A57 Link Roads

**8.2 Draft Statement of Common Ground
with Tameside MBC**

A57 Link Roads Development Consent Order 202[x]

Table 3.1: Statement of Common Ground (SoCG) Between National Highways and Tameside Metropolitan Borough Council Tameside Metropolitan Borough Council (TMBC) Table of Issues/Matters - Final Version dated 5 November 2021

**LEGEND**

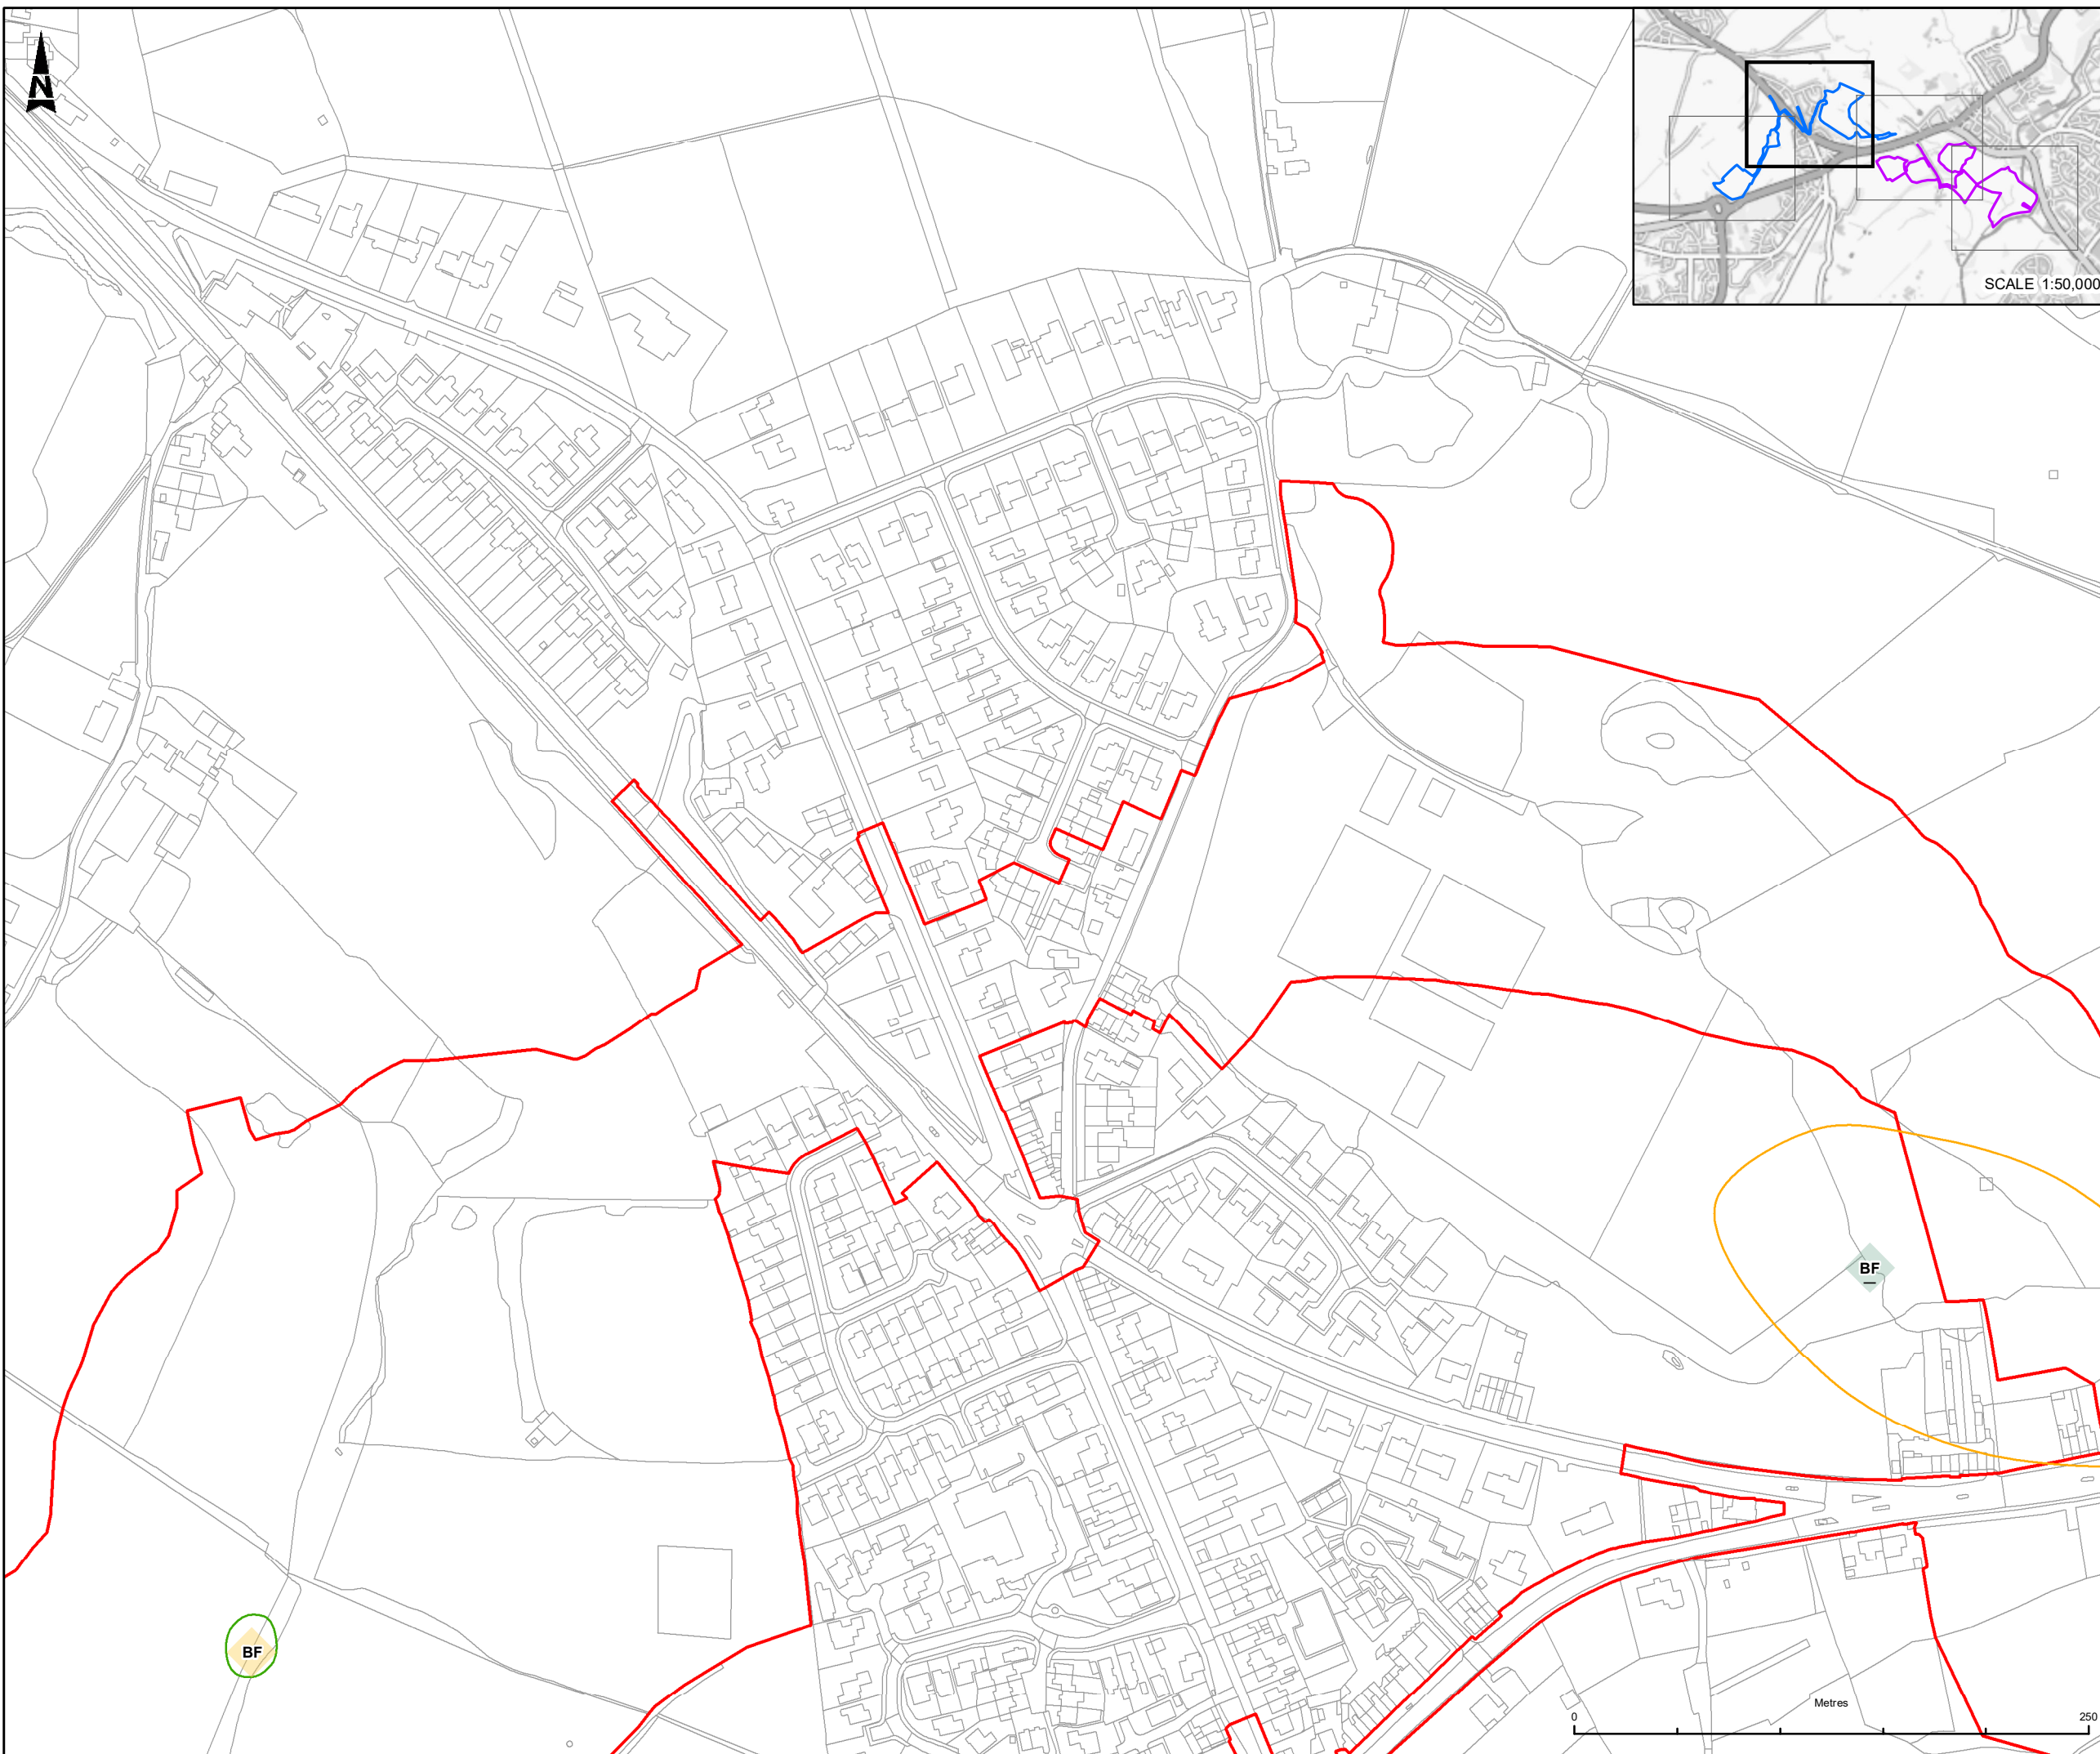
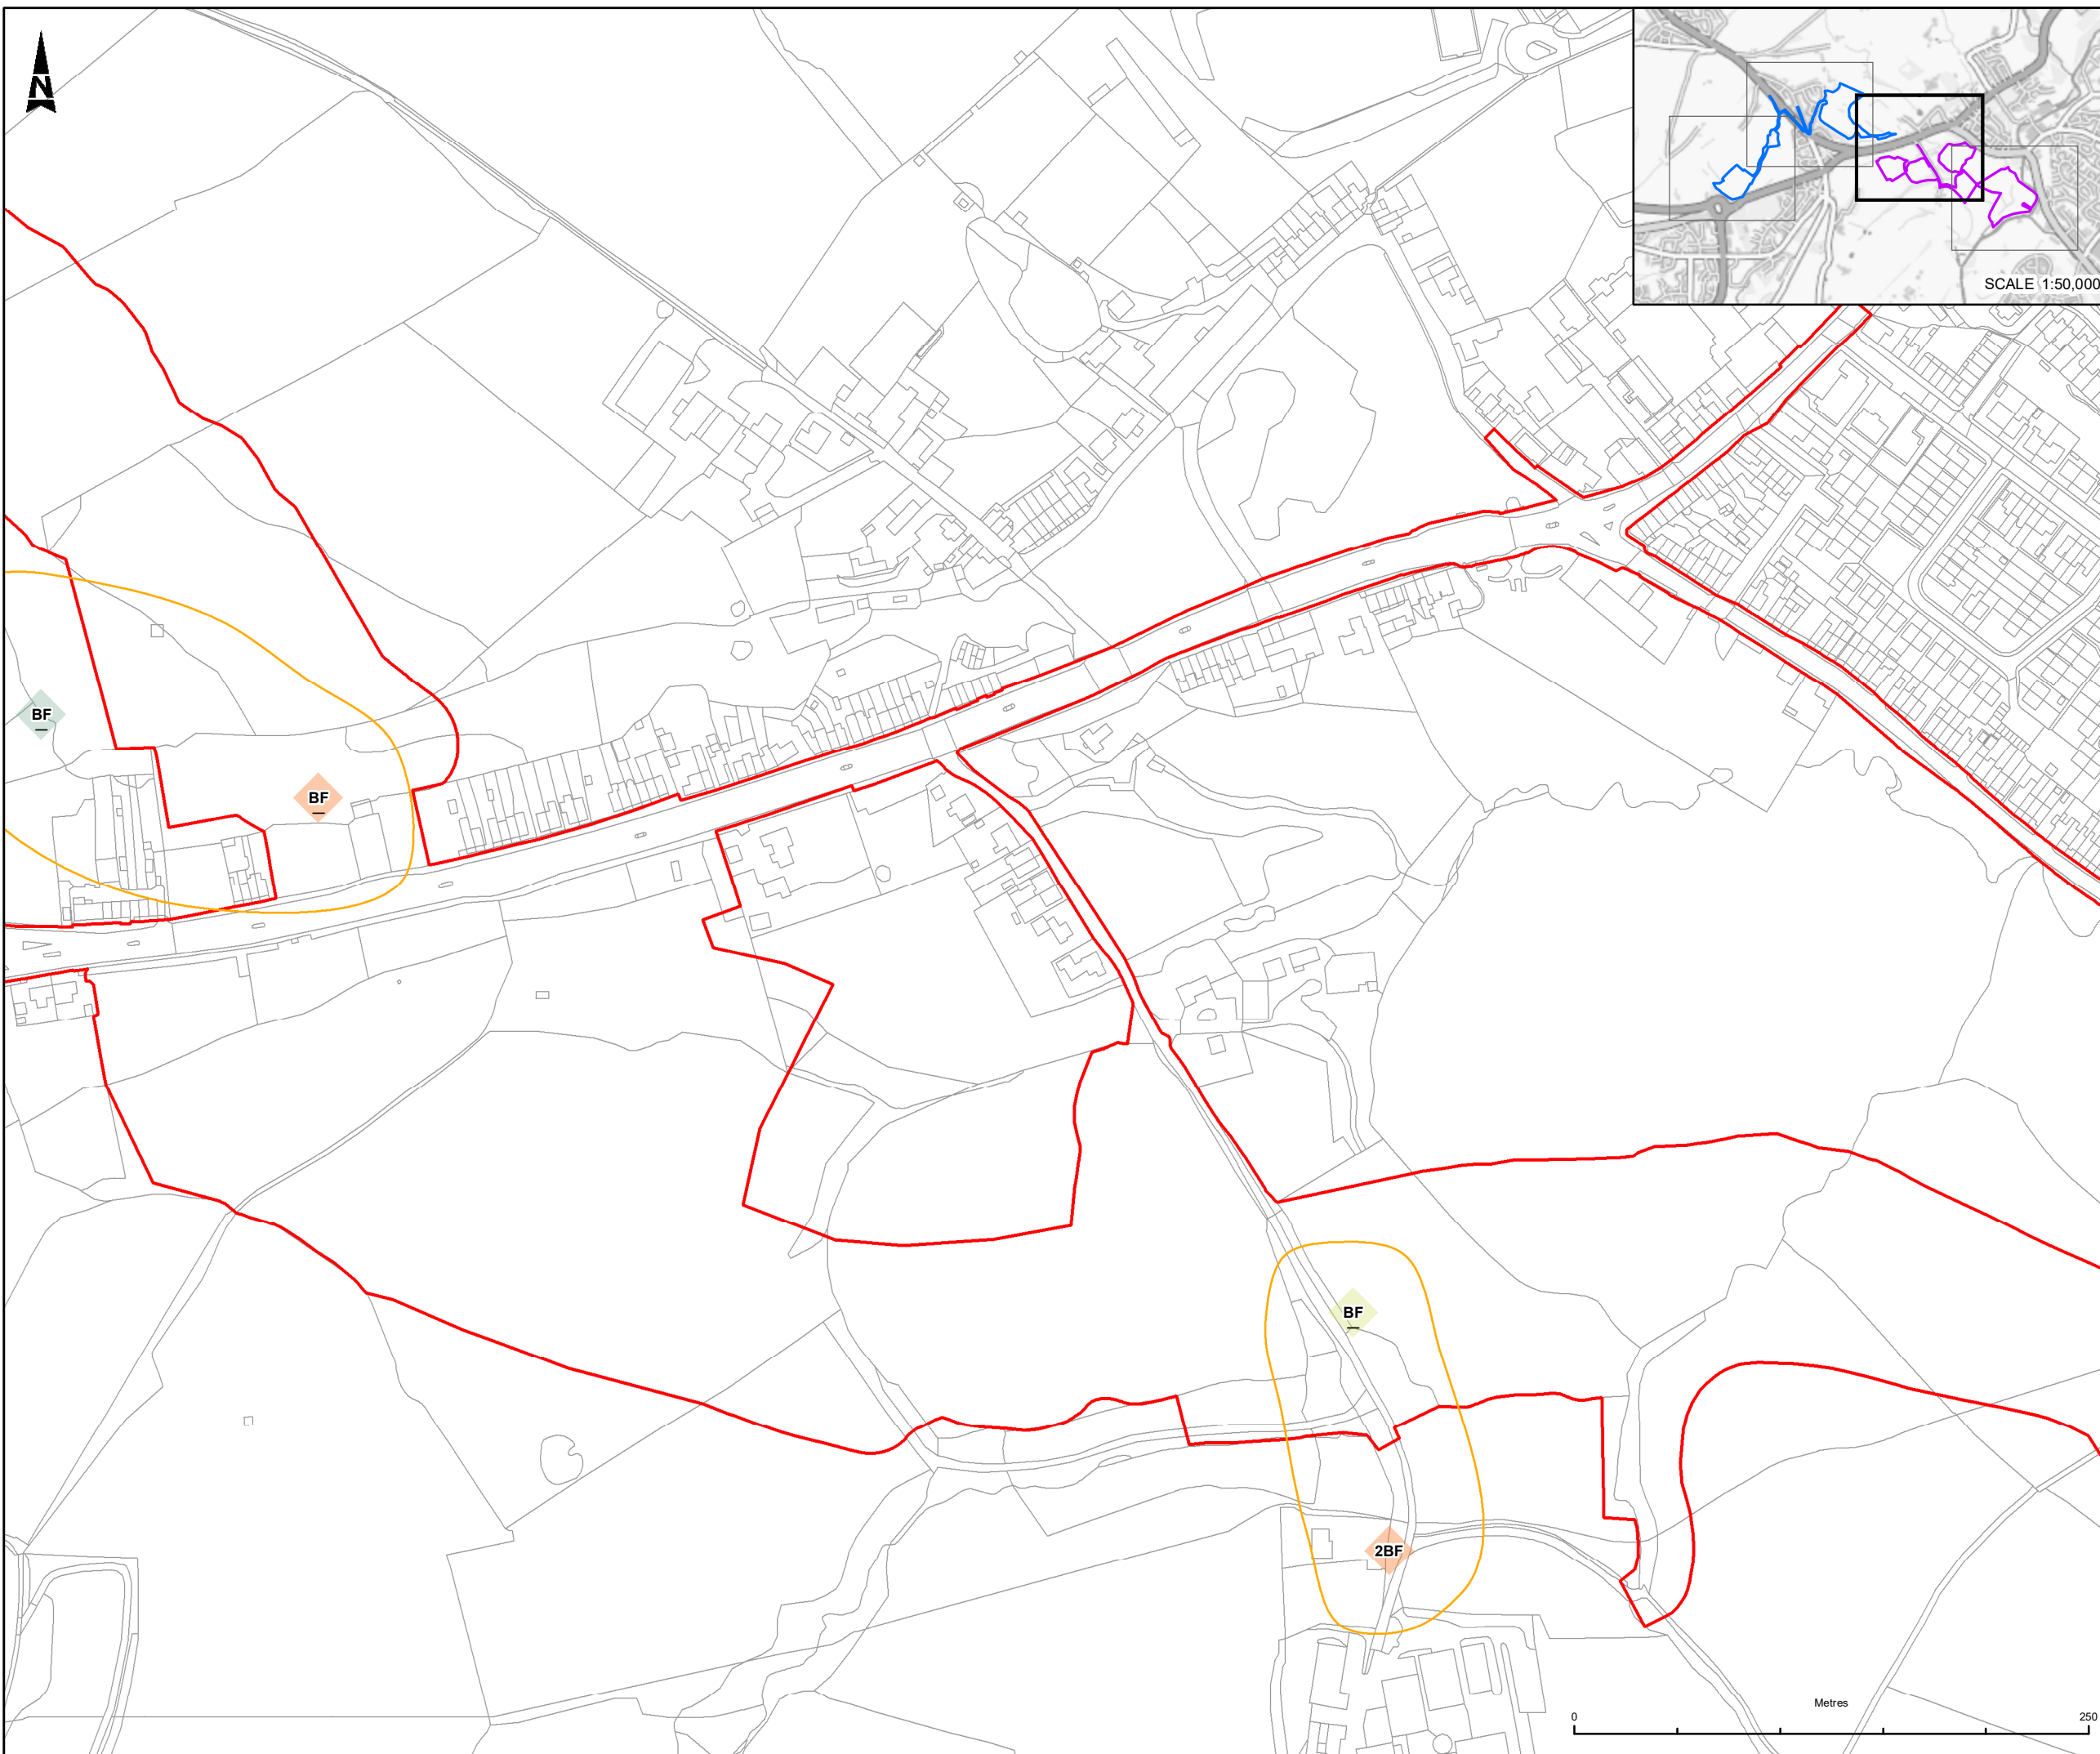
3.2	<p>Environmental Statement (ES) – Chapter 8 - Biodiversity [APP-064]</p> <p>Environmental Statement</p>	<p>Biodiversity</p> <p>Protected species</p>	<p>The Consultee stated that it would like to see the survey results, specifically regarding breeding birds. It described how protected species support is informally divided by organisation.</p>	<p>Breeding bird surveys have been undertaken throughout 2020 supported through desk studies. Full detailed results (including methodology) will be provided within the ES. Applicant noted contact. The methodology has been agreed with Natural England</p>	Agreed

SoCG Ref. Number	Relevant examination document	Relevant Issue	TMBC comment	National Highways response	Status
	(ES) – Appendix 8.1 – Biodiversity Baseline and Preliminary Assessment [APP-169]			National Highways to ensure ES has been shared.
